12. APPENDIX F - RFI TO HYDROCK

From: Gareth Jones
Sent: 20 October 2021 14:23
To: Jason Magee
Cc: Jason Walker
Subject: RE: [Hydrock: 13319_1-SBNO] C-13319 - Saltbox, Bognor Regis - Condition 15
Attachments: Level change summary and gradients_GJ_20.10.2021.pdf; Level change summary and gradients_GJ_20.10.2021.xlsx

Hydrock Bristol Civils understand that Arun District Council have issued a refusal on Condition 15 for the Saltbox, Bognor Regis project (Units 2, 4, 5, 8 and Access Road). As it states; the requirements of the condition have not been met as the verification report has not been completed by an independent engineer. With this in mind, please see attached all relevant information to be forwarded on so a formal review on the scheme can be undertaken.

HYDROCK PROJECT NO. C-13319-C	SCALE @ A1 1:250	STATUS AS BUILT ISSUE	A1
DRAWING NO. (PROJECT CODE-ORIGINATOR-ZONE-LEVEL-TYPE-ROLE-NUMBER) SAL-HYD-PH1-ZZ-DR-C-7022	REVISION C10

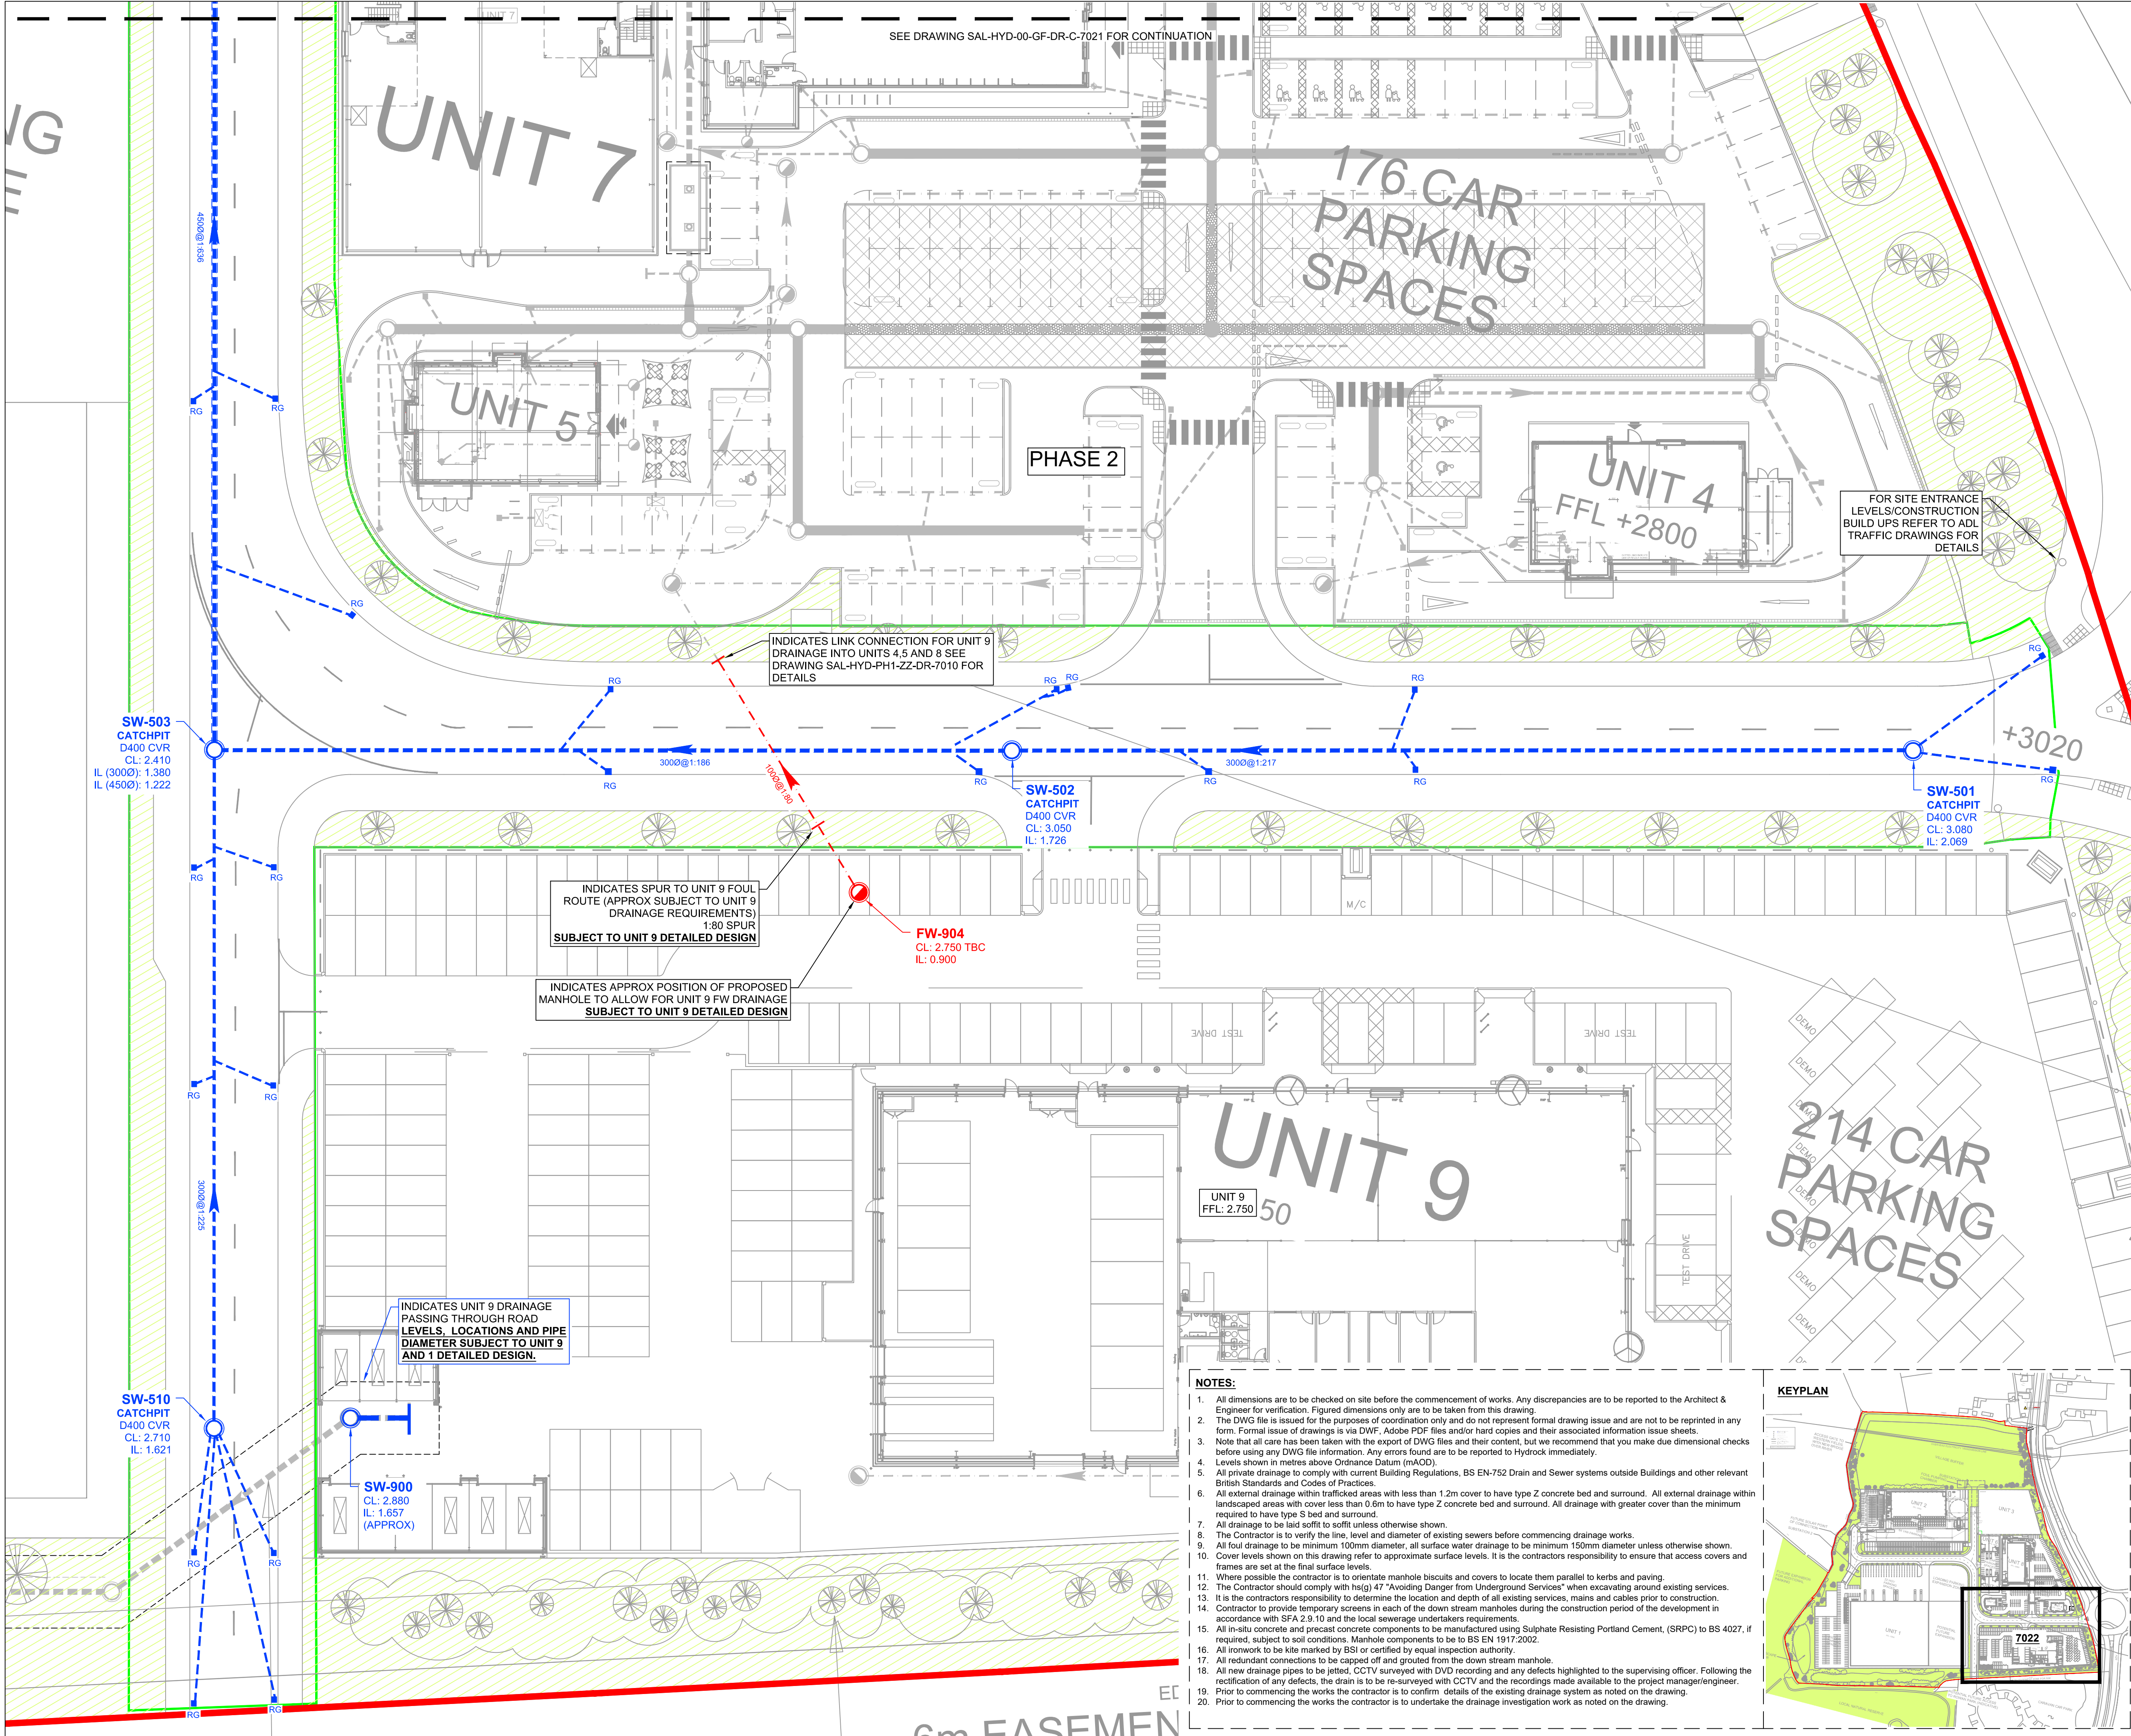
1. The majority of pipe falls
2. SW 209 manhole position and incoming pipes
3. SW 211a not shown on Hydrock Drawing
4. Review and check pipe and tank fall SW 213
5. Hydrock Access Road Drainage Layout drawing (SAL-HYD-PH1-ZZ-DR-C-7022 Phase 1) differs from ADBLY as built drawing, SMH-502a now removed. Hydrock to update
6. SW 504 ADBLY manhole reference incorrect, differs from Hydrock as built drawing
7. SW 505 ADBLY manhole reference incorrect, differs from Hydrock as built drawing
8. FC 501 ADBLY manhole reference incorrect, differs from Hydrock as built drawing
9. SW 901 to 903 length of runs excessive, confirm this is acceptable for maintenance
10. There are many discrepancies with Invert Levels notation. Please update all to match ADBLY.
